From: Paul Cann
Sent: 15 May 2017 14:46
To: Planning.Responses
Subject: RE: Planning Consultation on: AL/51/17/PL

Engineers comments in respect to surface water drainage:

APPLICATION AL/51/17/PL

Description of Works: 1 No. dwelling

Client	Bryan Fry
Drawing Title	Surface Water Drainage

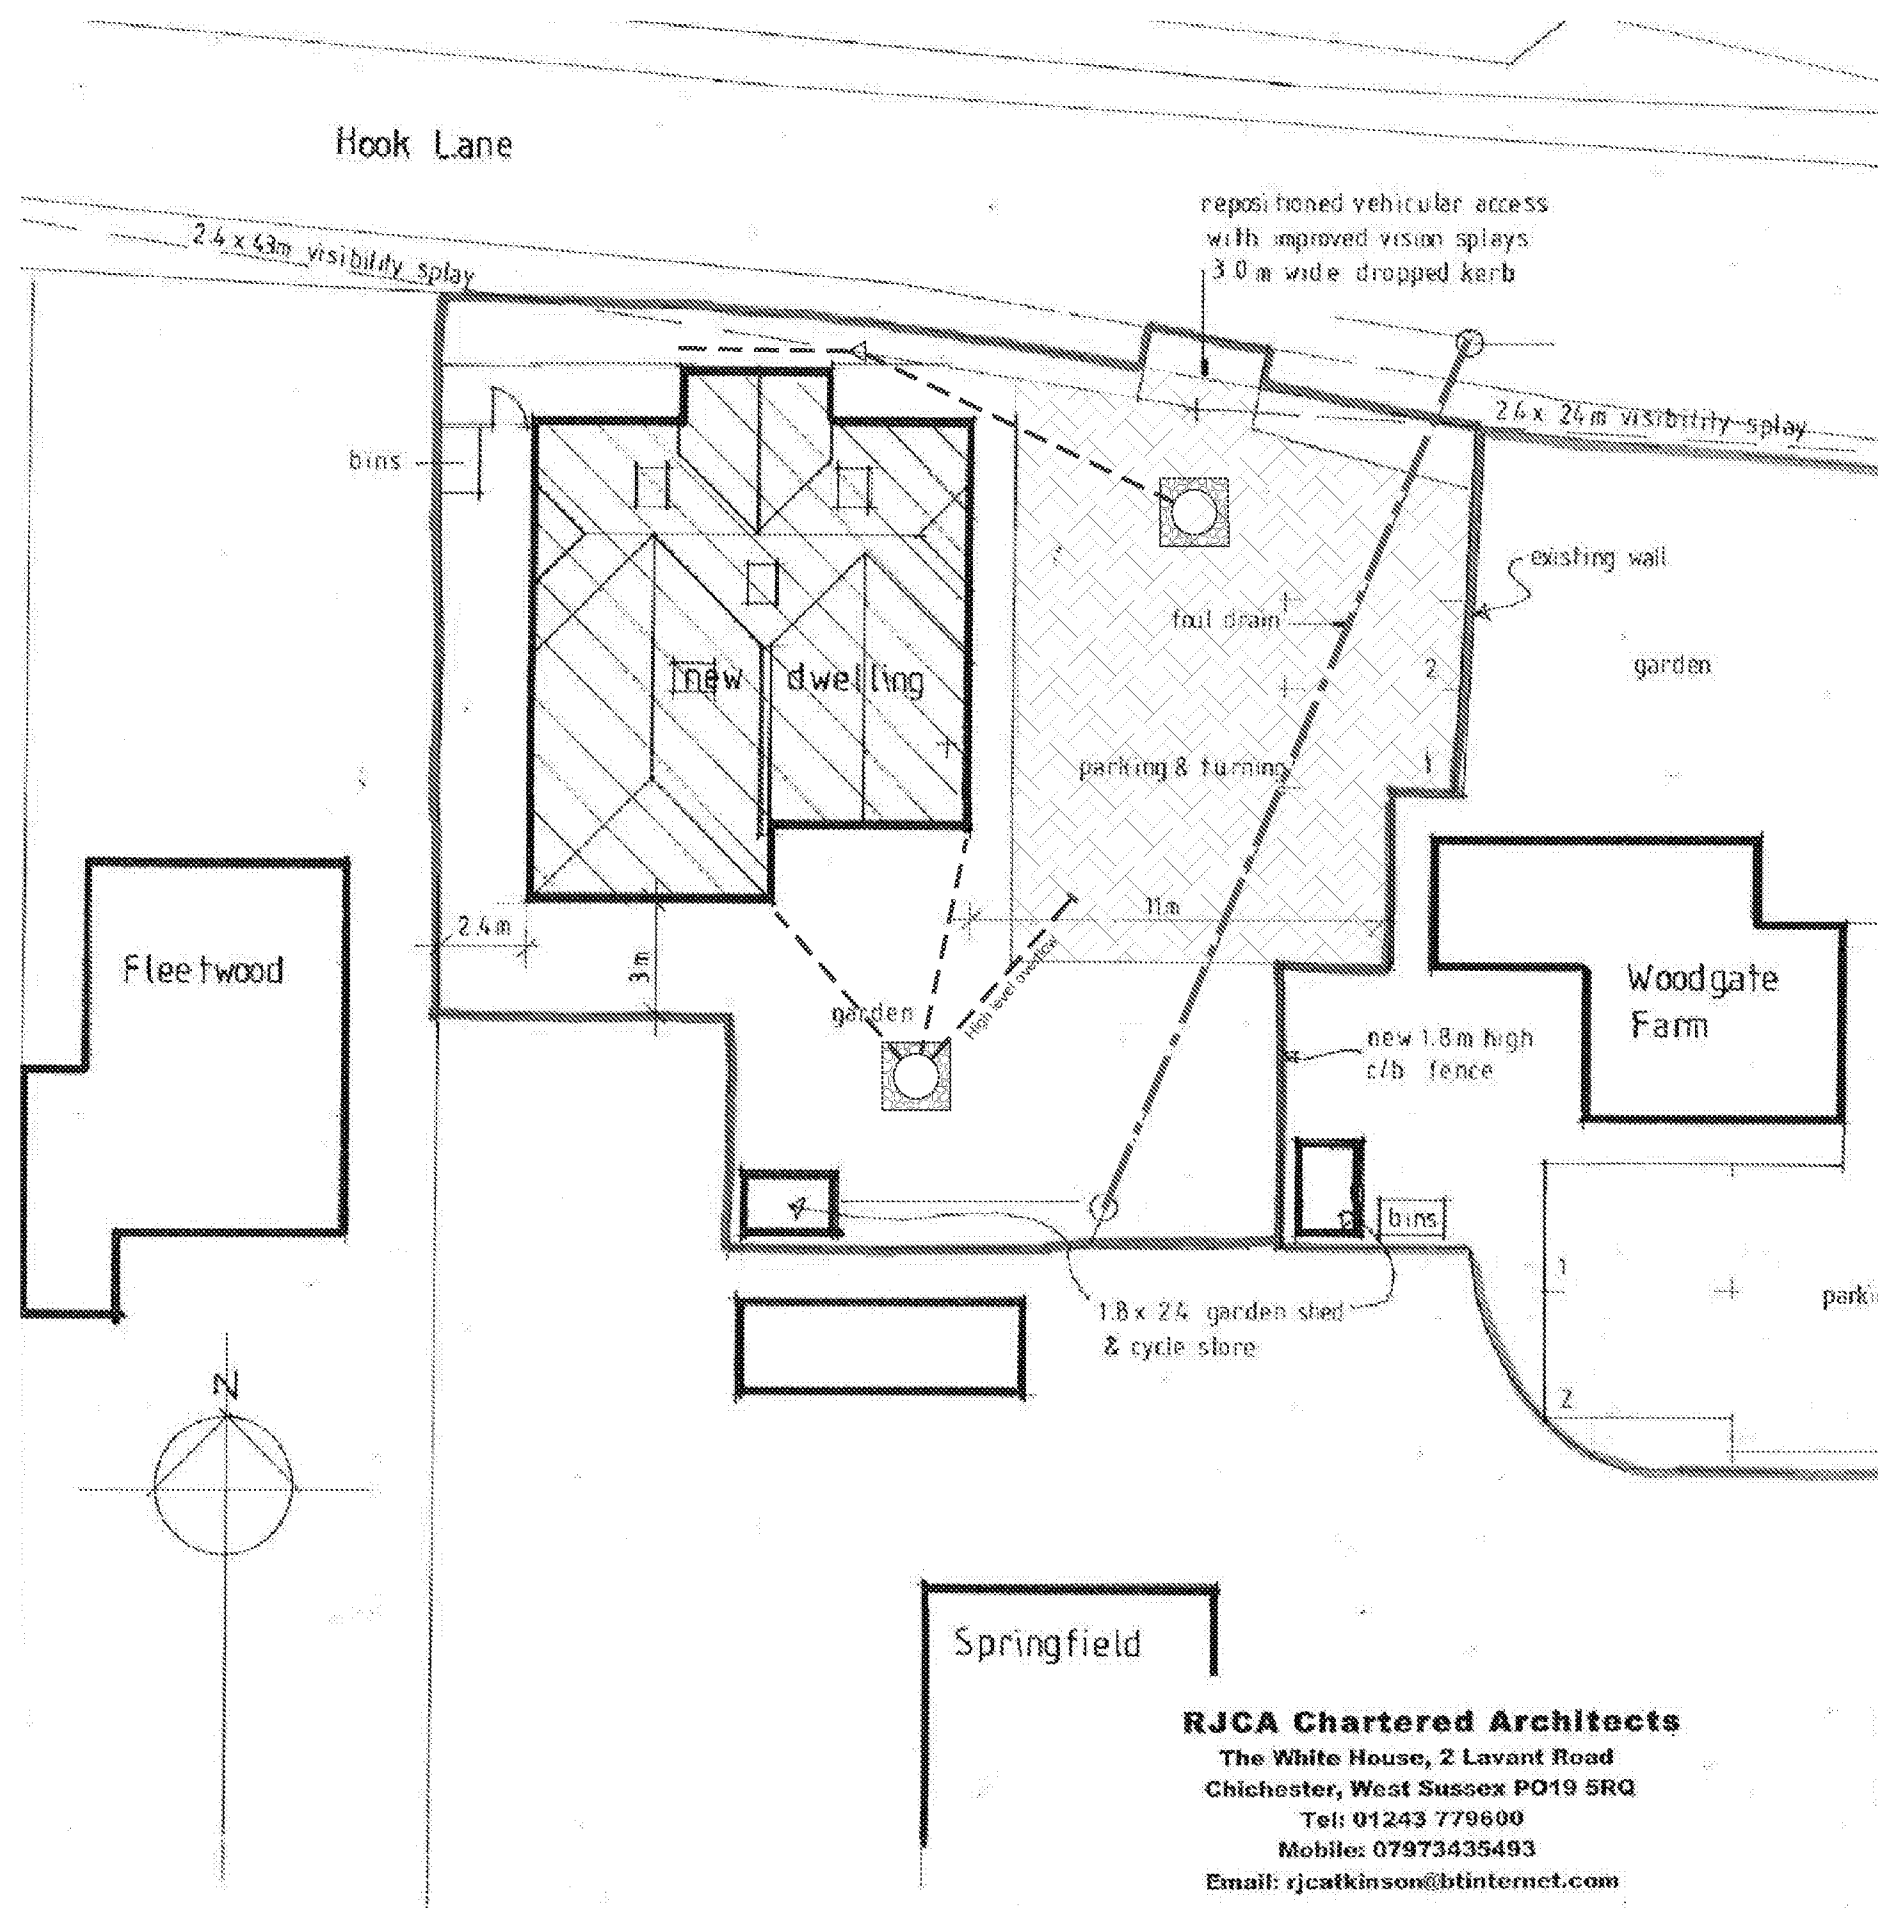
A significant of work has already been undertaken in terms of the surface water drainage design. To support the proposals, hydraulic calculations and full construction details will be required.

Please apply standard condition ENGD2A.

Please note that a public foul sewer crosses the site, so Southern Water should be consulted.
